Responses to EPC June 11, 2019 Comment Letter:

Transportation / Traffic Impact Study (TIS)

1. Separate roundabout design comments. **Unresolved; response from February 25 comments not received. Chris sent responses to the comments in an email in late March. These responses are as follows:**

**SIGNAGE &
STRIPING
PLAN**

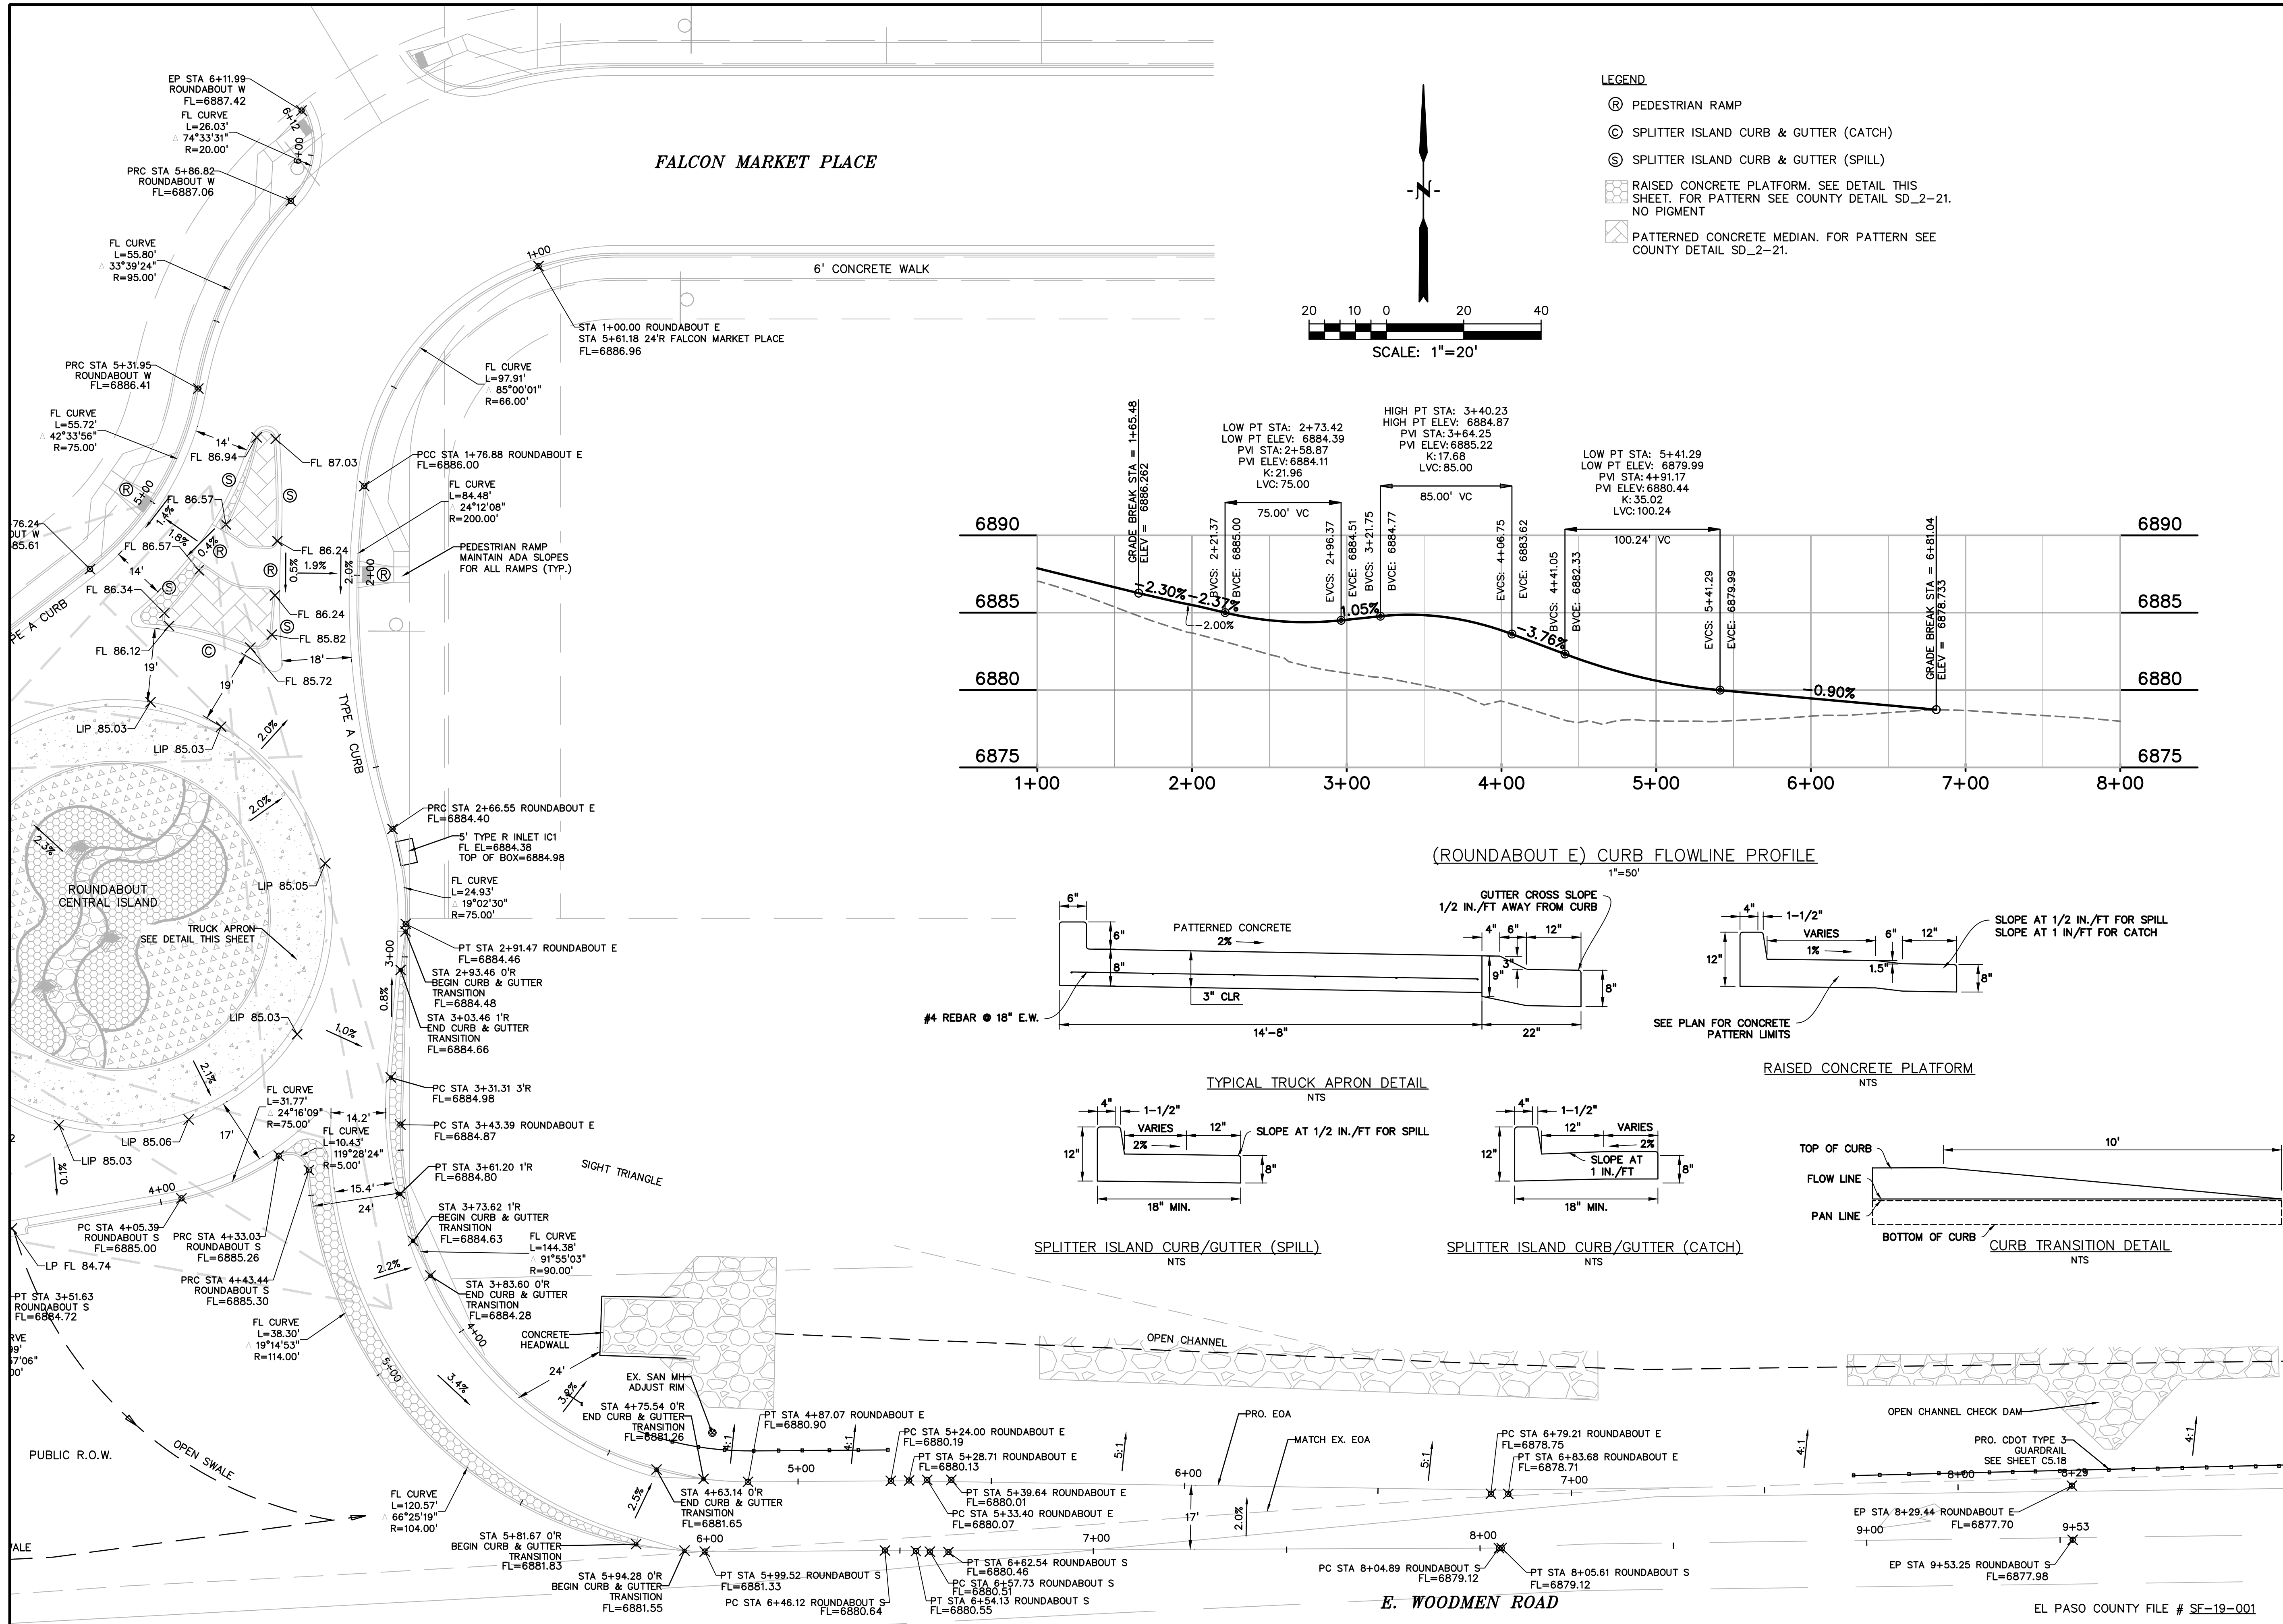
7. **(14) Reduction of the speed limit on Meridian Road between Woodmen Road and a location near Owl Lane (verify MUTCD requirement) is being considered by the County Engineer if this*

development proceeds. Provide signage as appropriate on the plans. Unresolved; this signage can be confirmed with the County Engineer; address on the plans. Completed by Drexel Barrell.

SOUTH
ROUNDBOUT
SIGNAGE

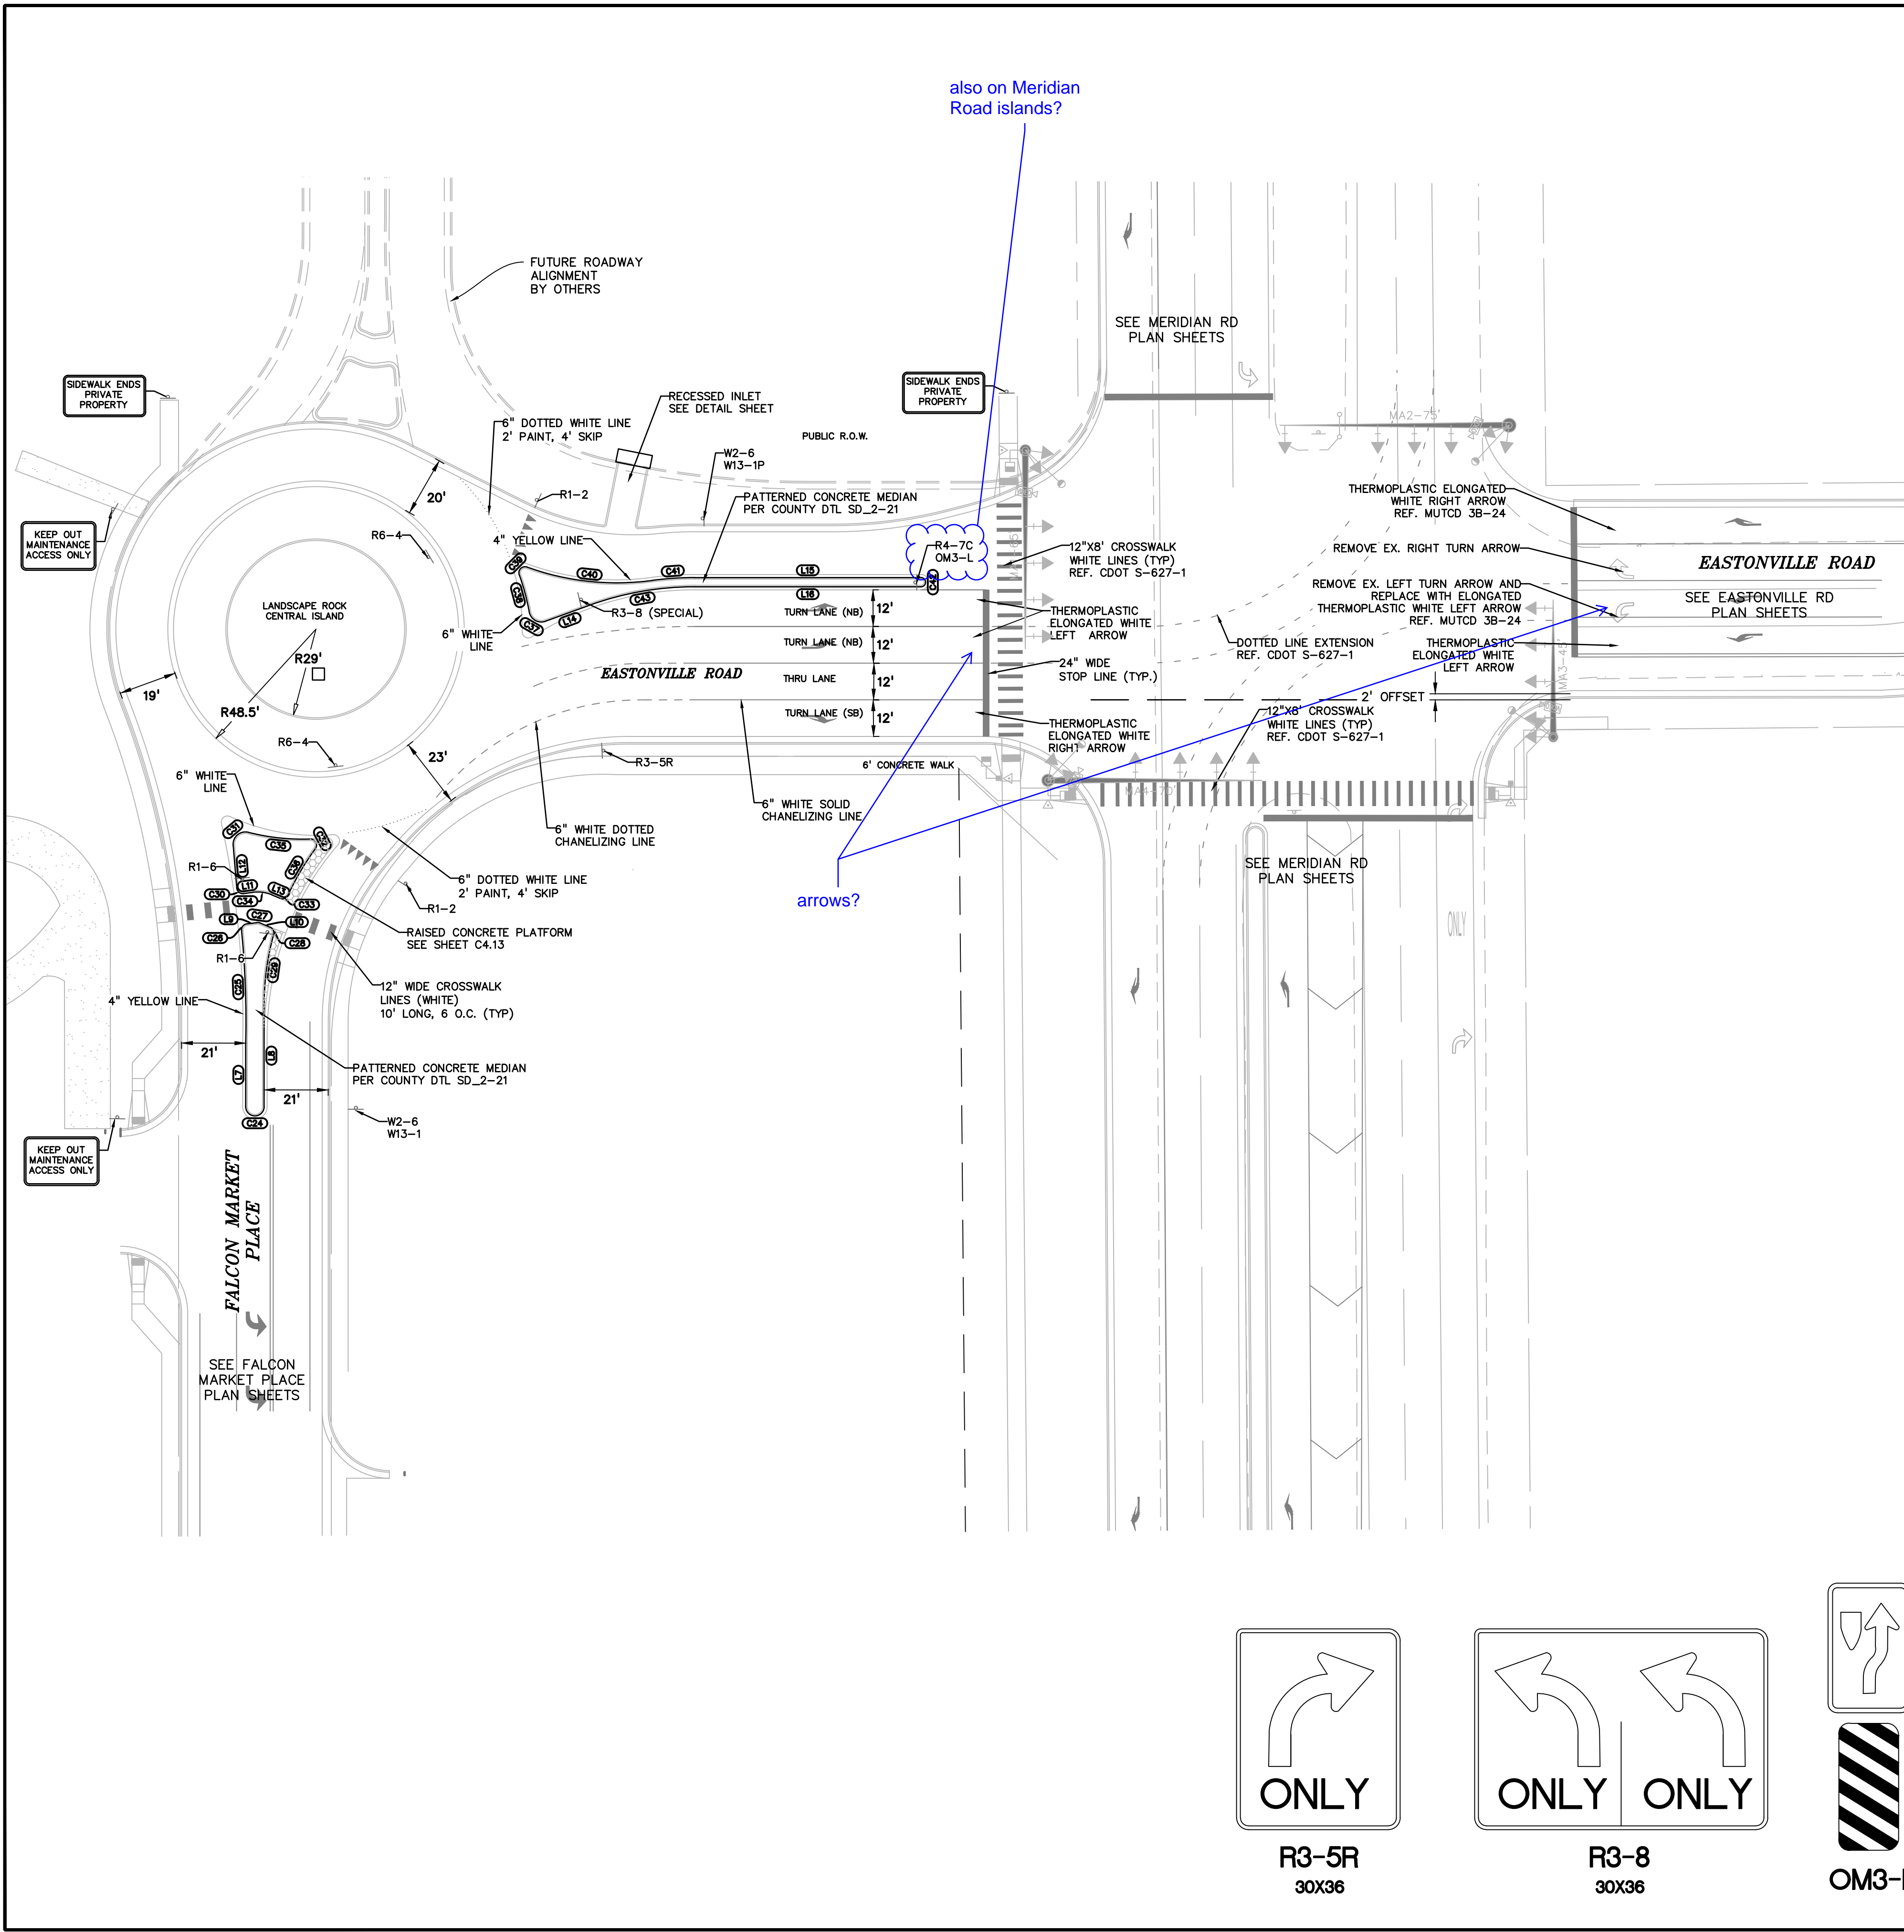
- Add some chevron signs on the SW roundabout approaches – coming in off Woodmen and on the EB approach from the N. Frontage Road. **DONE ON STRIPING PLAN Completed by Drexel Barrell.**
